From: Marsha Kearney <rmeek1978@gmail.com>
Sent: Monday, August 03, 2020 9:02 PM
To: Richard Stevenson
Cc: p crump; Ron Bohannon; rick@rba81.com; gnh5976@gmail.com; 1garciagang@gmail.com; mdmiraba@msn.com; meganfitz@live.com; bcreel@msn.com; frandimarco@msn.com; cfmirabal@gmail.com; ruffkat@yahoo.com; david.m.lopez@msn.com; garnand_lu@yahoo.com; kmcvey124@comcast.net; tjmurieta@msn.com; nenaperkin@gmail.com; avalgman12@gmail.com; scott.templeton@comcast.net; chavezdyx4@yahoo.com; mccormackdj@comcast.net; erin.coffman@yahoo.com; huerta.loretta58@gmail.com; gayle.binkley@me.com; marshakearney@gmail.com; nauticalhutch@gmail.com; miladybutler@yahoo.com; rfasel@fed.net; Gomez, Angela J.; Wolfenbarger, Jeanne; Gould, Maggie S.
Subject: Re: [#2020013] Wintergreen Apartments DRB questions (PR-2020-004030)

The intent of this email is to provide responses to the questions raised by neighbors at the DRB hearing on July 22nd 2020, in regards to the proposed Wintergreen Apartment project City project number PR-2020-004030.

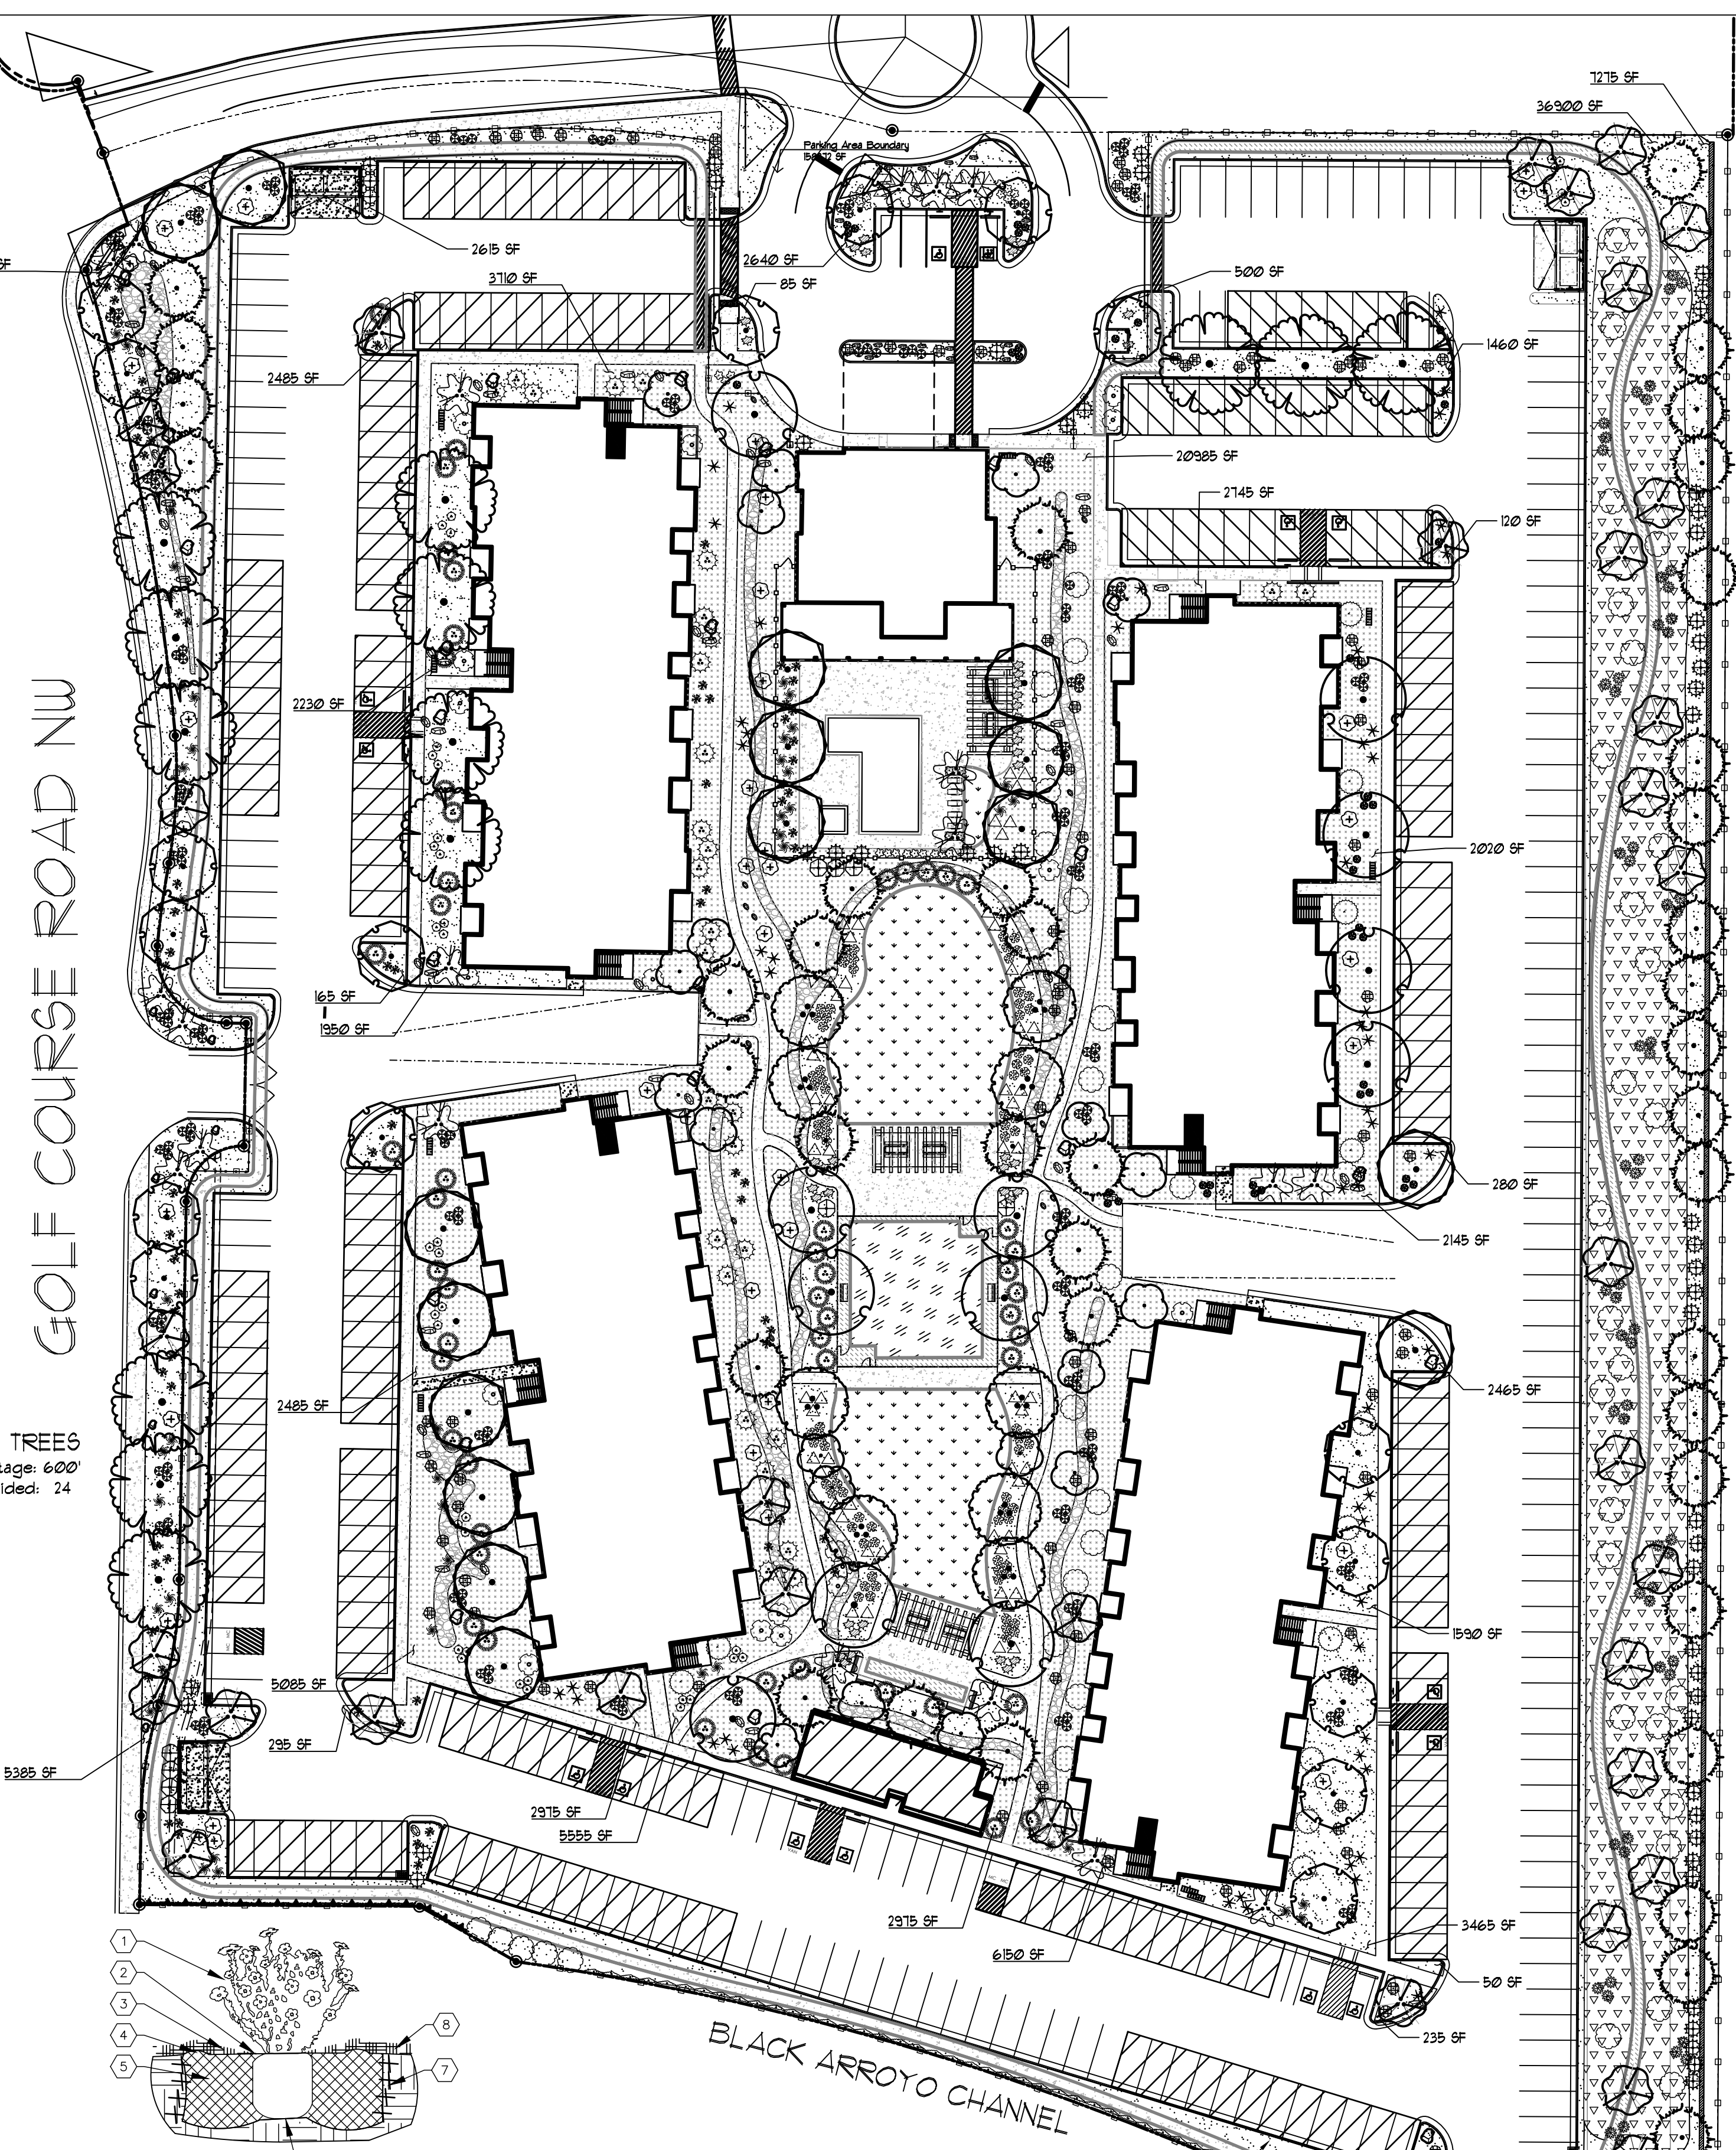
- We also would like the landscape plan to include more mature trees, to protect immediate privacy. The current plan has at least 10-year maturity

- We would like plants that do not affect allergies. Juniper plants are a major contributor to allergies.

Response: 6-ft plus high trees will be installed at install for the Austrian Pine species, Chinese Juniper planted as 5 gal shrubs, the other tree species shall have a 2-inch plus caliper.

- Austrian Pines / *Pinus nigra*. Uncommon tree allergen, minimal needle drop with regular irrigation.
 - Chinese Juniper / *Juniperus chinensis* – ‘Spartan’ (narrow) variety, planted as 5 gal shrubs. FEMALE TREES ONLY per compliance with City Aeroallergen Ordinance.
 - The city tracks and puts out daily air quality pollen counts. Junipers, a common allergen, are included. Pines, an uncommon allergen, are not included.
- We want Trash Bins moved away from the East side of the development, away from homeowners’ properties.
